**From:** agilityaussie@aol.com  
**Sent:** Wednesday, February 18, 2015 3:09 PM  
**To:** Kaycee Hathaway  
**Subject:** Comments Re: SEPA, Grow Bros, 2990 Rader Rd, Ellensburg WA

I am a resident of Rader Rd, and am writing to express my concerns, and submit my comments on the SEPA Determination for Grow Bros, 2990 Rader Rd., Ellensburg, WA.

ENLARGED SITE PLAN

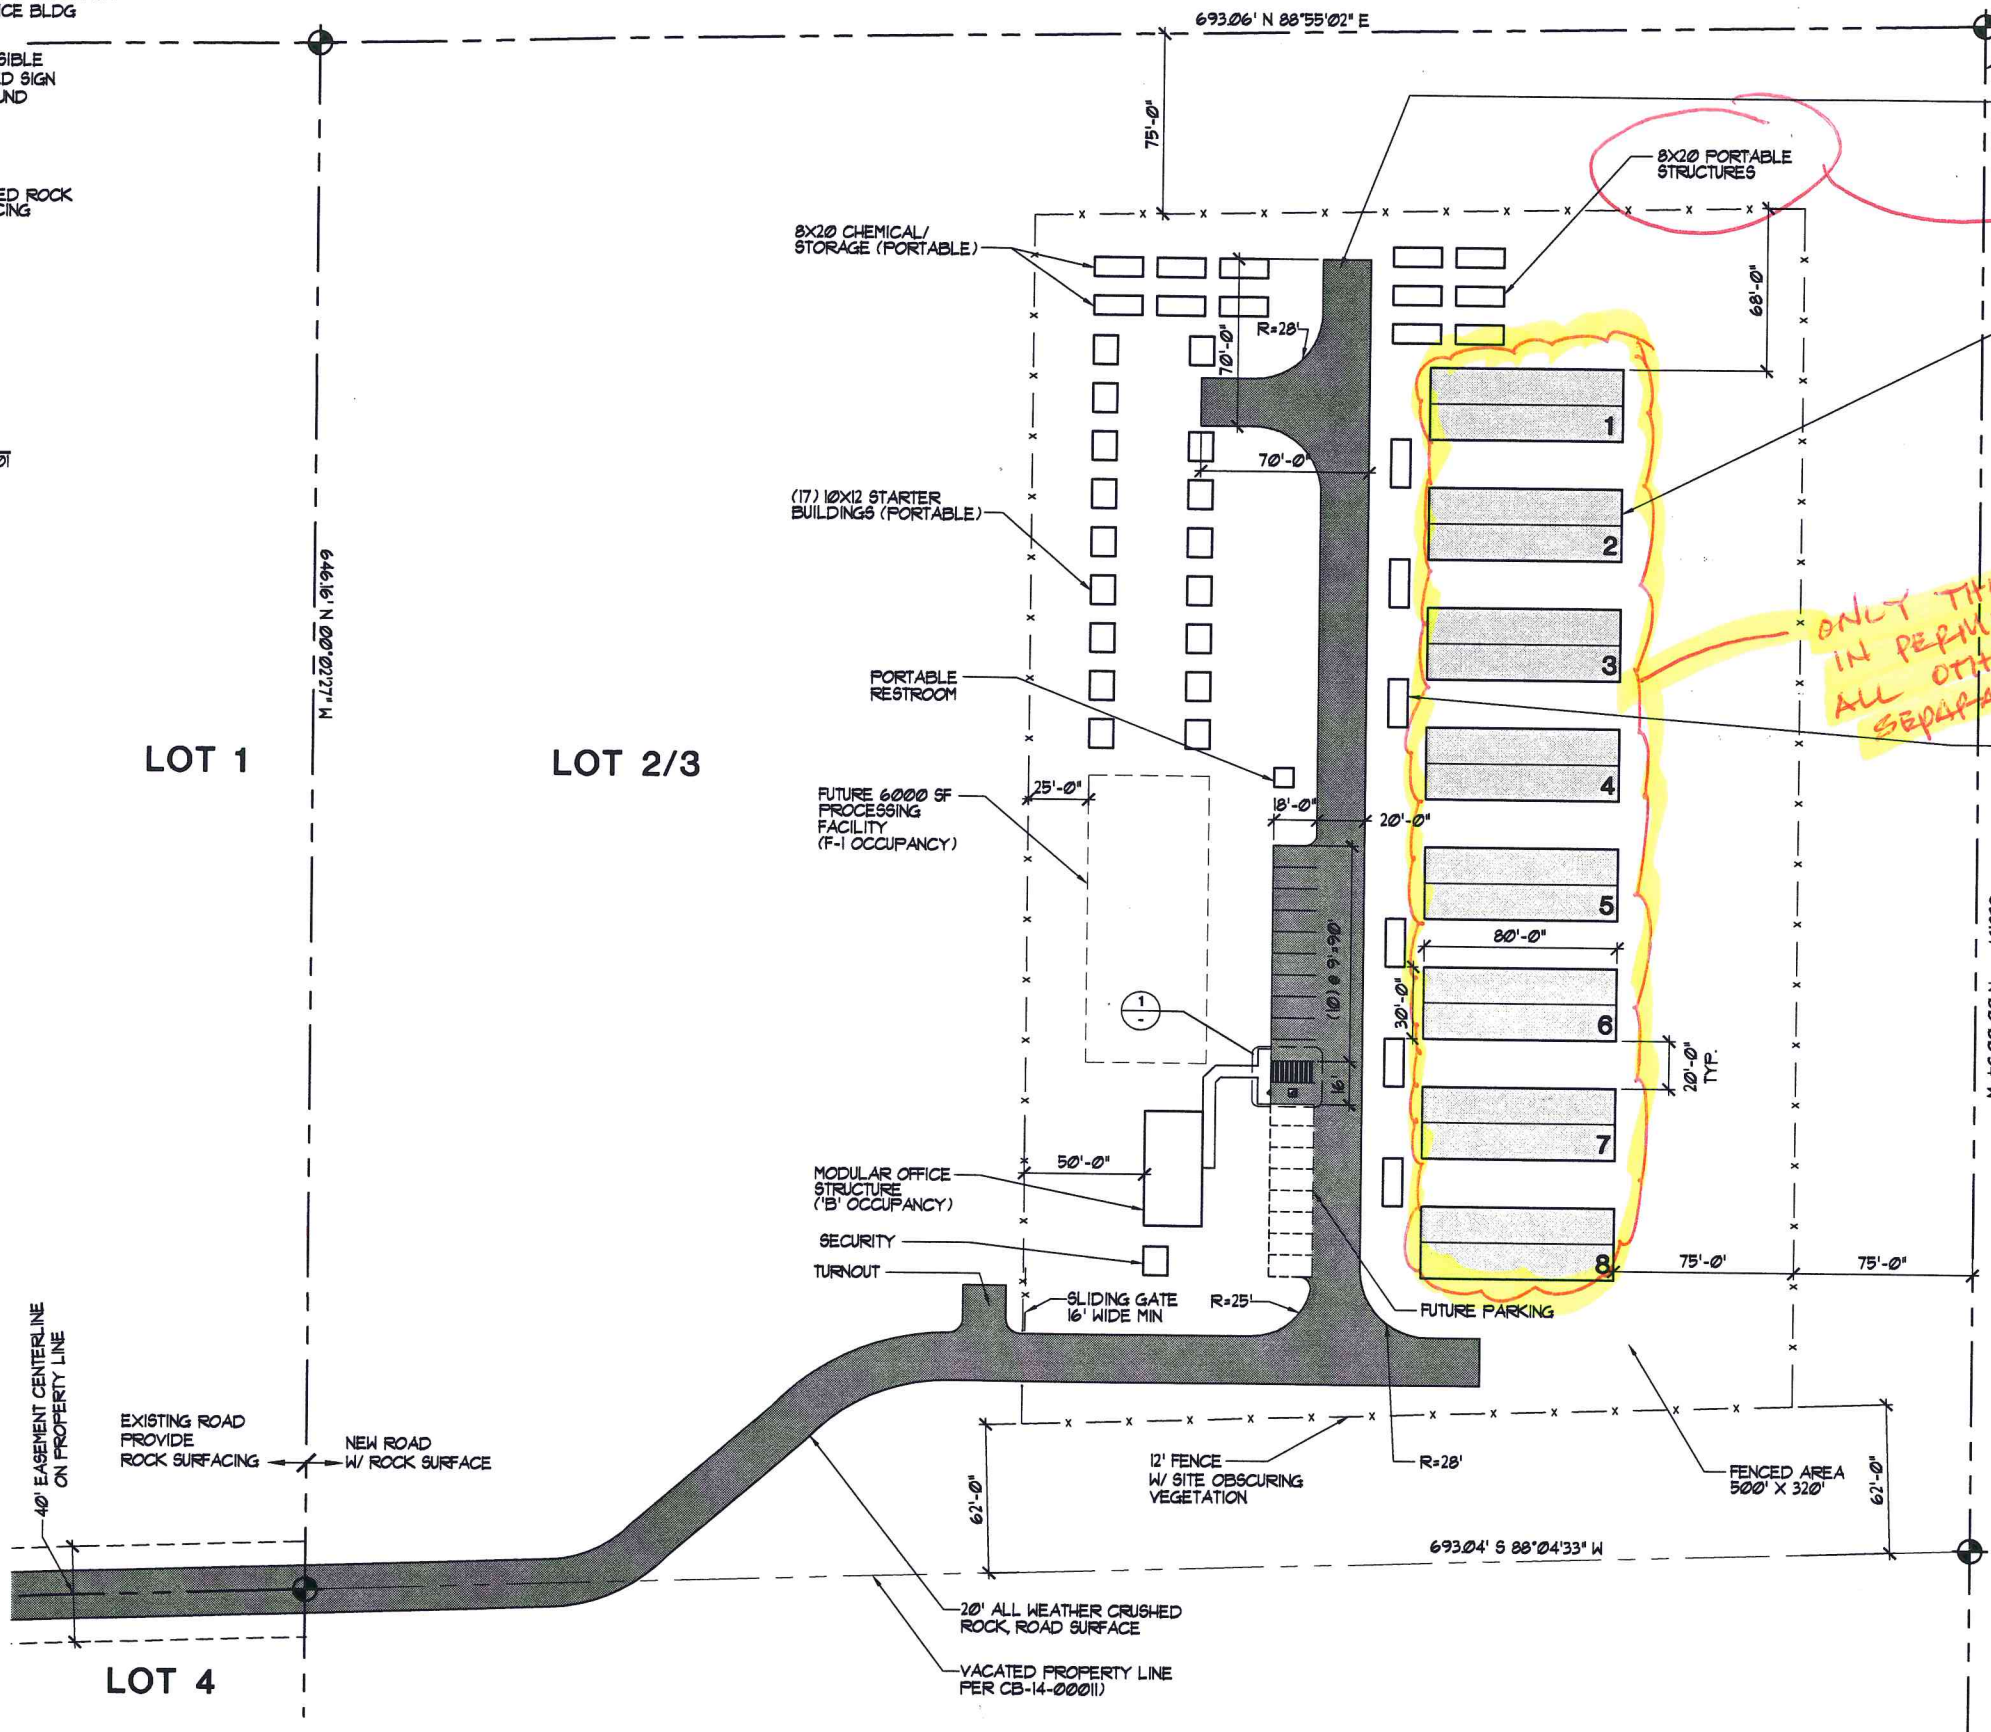
Grow Bros application says that there will be 4-5 workers at peak times. What about in the future phases of the project? It seems more than a little ambitious to me that a project of this size will only require 4-5 employees. In addition, there are 19 parking places on the plans-what are those for?)
